Planning Application Ref: EP/70/14/T

Location : Midholme, Sea Lane Close, East Preston

Description of works: 1 x Horse Chestnut – reduce to a point 50cm above previous topping out cuts

Midholme Appendix 5 - tree survey plan

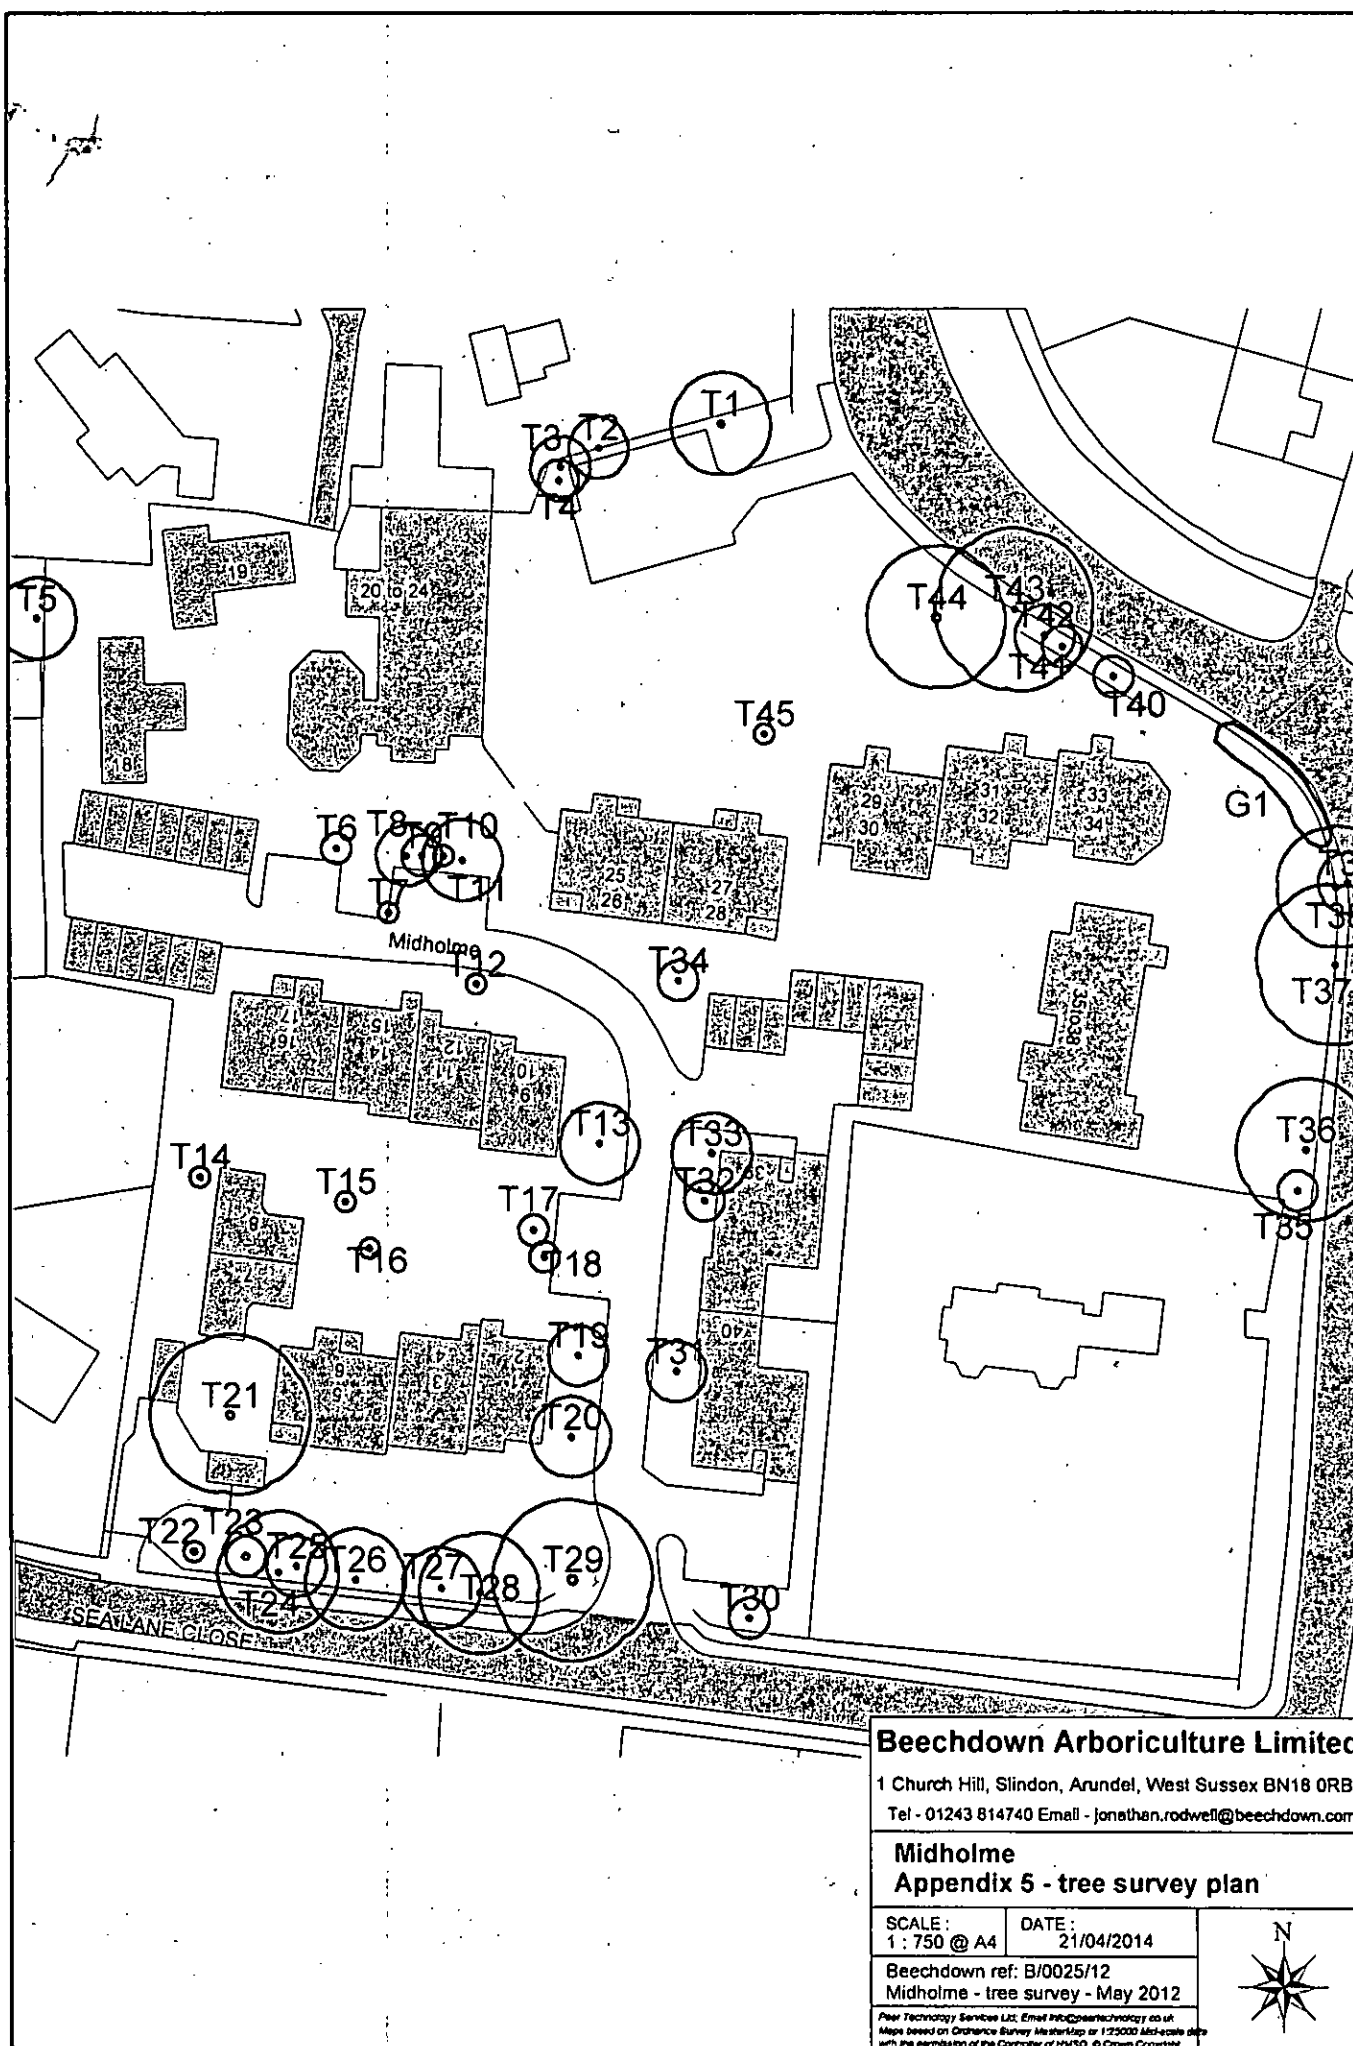
T1 Horse Chestnut *Aesculus hippocastanum* Height = 15m Avge spread = 8m Age = Mature Grd Cl = 2m

- This is a mature tree positioned at the entrance to the site adjacent to the main road and is thus a prominent tree.
- There is evidence that this tree has been very heavily topped out before at about half of its present height and then allowed to grow out from this again over time – this is not ‘pollarding’ as the applicant refers to as this would be a pruning operation repeated on a regular (usually a maximum of 2 years) cyclic basis.

- The precedent for heavy topping and lopping has been set so I am not going to refuse this application outright but rather recommend that the work to bring it back down to the level of previous cuts is undertaken in two phases of work two years apart and then I suggest that they apply every 18 months to 2 years to have the regrowth removed so that we get back to a cyclical pruning event that can truly be classed as ‘Pollarding’ and the tree will readily cope with this rather than having one major pruning event every 5 to 10 years which is very stressful on the tree.

I **OBJECT** to the extent of works as applied for because they are excessive and contrary to BS3998 and current industry guidelines and will be very stressful for the tree.

- Reduce the height and lateral spread by 3m overall making all final cuts adjacent to living growth points.

- *Where whole branches are to be removed final cuts close to the trunk or branch union are to be made as shown in Figure 2 of BS3998:2010 and all branches which need to be shortened are to be cut at the correct angle and adjacent to a live bud or lateral as defined and illustrated in BS3998:2010.*
